**OXFORD CITY COUNCIL PLANNING PERMISSION ref. 20/02631/FUL  
APPLICATION TO VARY CONDITION NO.7**

4 Proposed Site Block Plan
1:500

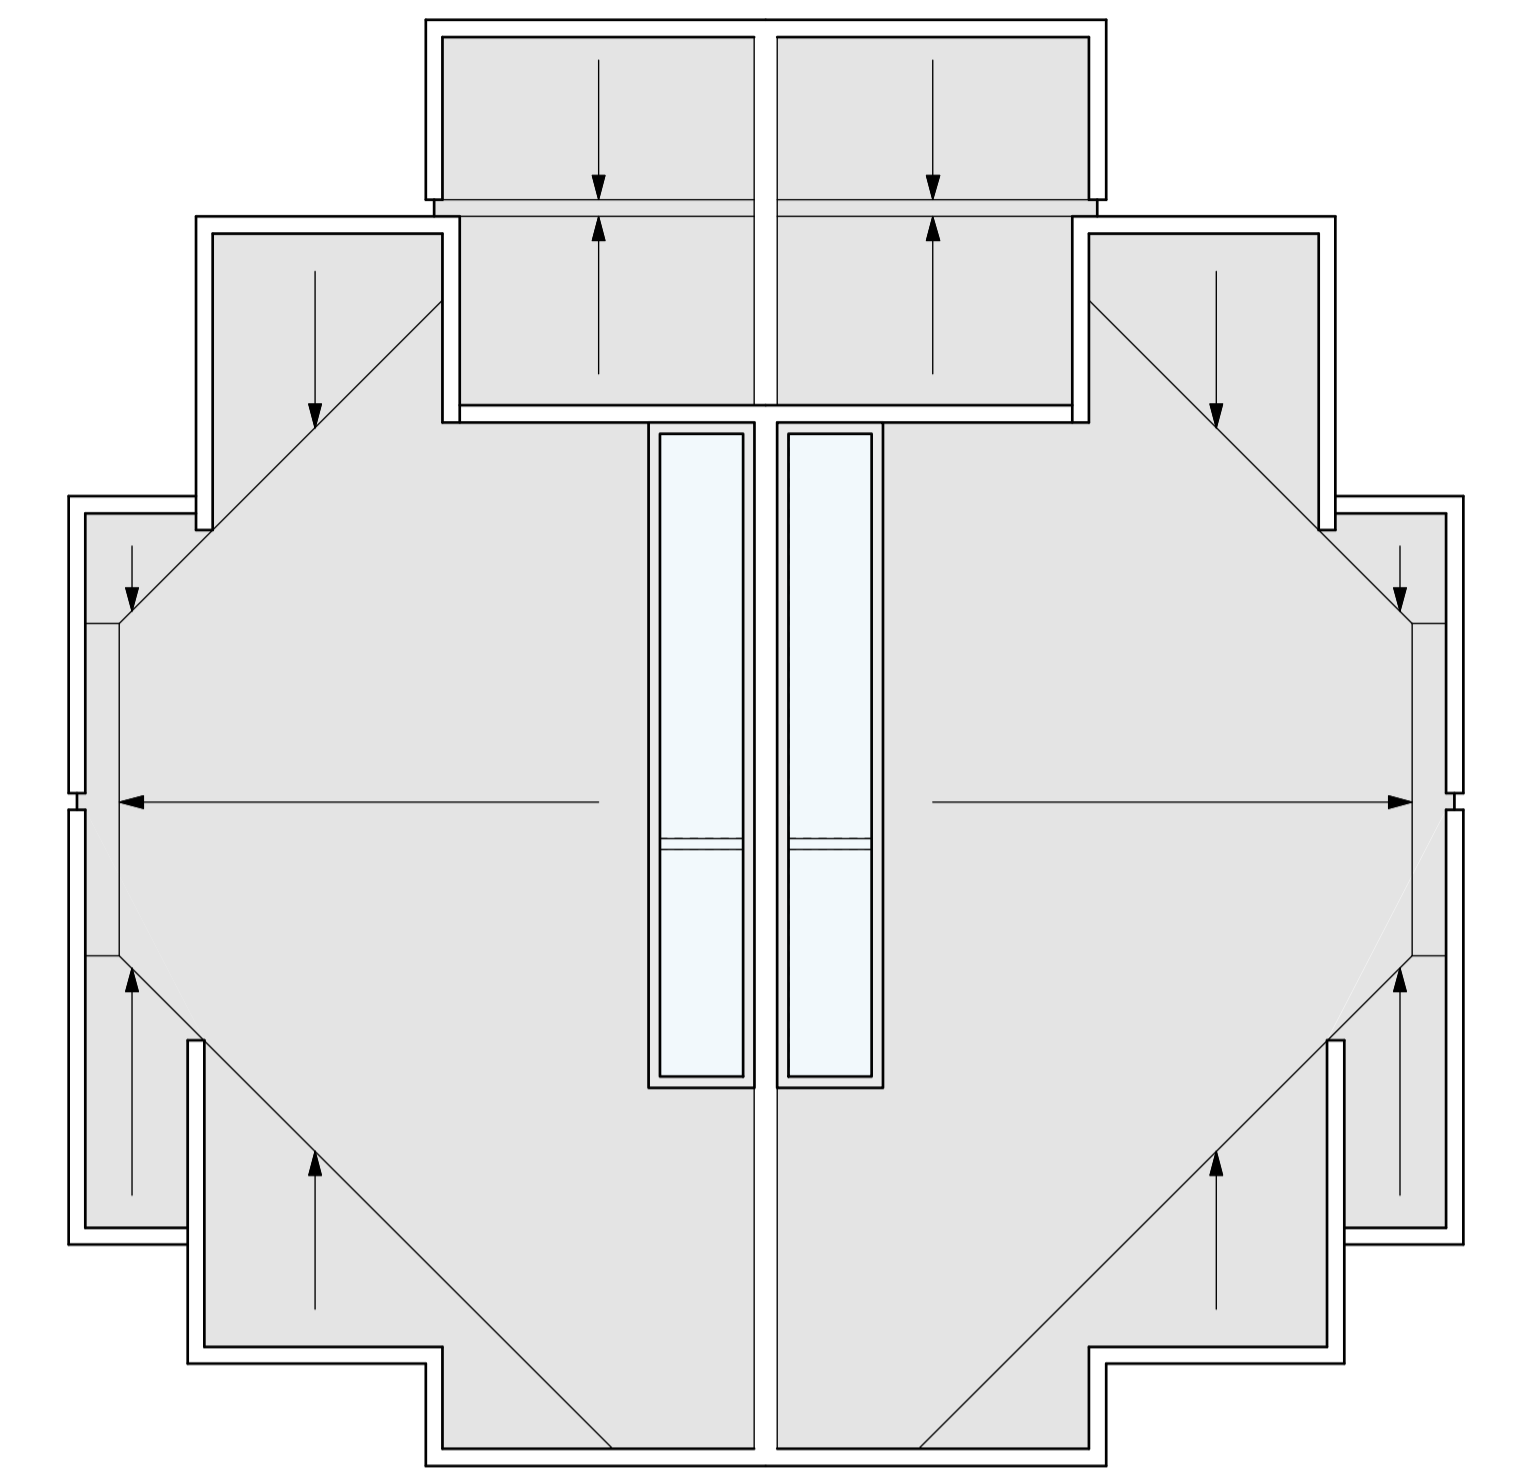
In order to comply with the planning officers' interpretation of OCC policy M3, during the planning negotiation process the site plan was amended to remove the parking space in front of one of the houses. This was the only way to make the design acceptable to the officers and secure planning permission. So on the approved site plan drawing ref.348.P.003D, one parking space is shown within the curtilage of house no.1, whereas house no.2 has no parking space within its curtilage.

The issue is that, if one house has no parking space, the development cannot comply with the accessibility requirements in the Building Regulations and so will not be able to be built and occupied. The need to stick with the approved site plan is laid down in planning condition no.7, which specifically requires the landscaping of the front gardens to be designed and built to prevent any further parking within the curtilage: that is why we are seeking to vary that condition.

As was demonstrated within the planning application, the owners of the development site do not have control over the shared private drive or the area where the drive widens directly in front of house no.2, as shown hatched on the approved plan 348.P.001B. This has a covenant on it which means cars cannot be parked there with certainty. Any visitor to house no.2 cannot park on the lane or anywhere nearby; the closest available parking is located on Squitchey Lane approximately 100m from the development red line boundary. The private driveway itself is topped with loose gravel which is not a viable ground surface to enable wheelchair users to approach a dwelling. This means that unless the visitor can park within the development area, the house will not comply with Building Regulations and so is unbuildable.

This is obviously very serious, effectively rendering the permission null and void, and this is the issue we seek to remedy with this application for a variation of condition no.7. But we do not consider that allowing a parking space in front of house no.2 would contravene policy M3.

On this basis, we are applying for the wording of condition no. 7 to be varied as follows or similar to be agreed:

***Notwithstanding the approved plans, prior to the occupation of the approved dwellinghouses full details of the proposed layout of the front gardens, including one disabled parking space for each dwellinghouse and the boundary treatments, shall be submitted to and approved in writing by the Local Planning Authority. Work shall then only be carried out in accordance with the approved details and the approved plans and the approved layout and boundary treatments shall be installed prior to the first occupation of the approved dwellinghouses. Notwithstanding the provisions of Part 2, Class A of Schedule 2 of the Town and Country (General Permitted Development) Order 2015 ( as amended) or any order amending or re-enacting those provisions the approved boundary treatments shall be retained and maintained at the approved height in perpetuity.***

***Reason: To ensure no additional parking is possible outside the necessary disabled parking spaces for each house and so ensure the proposal is compliant with Policy M3 of the Oxford Local Plan 2036.***
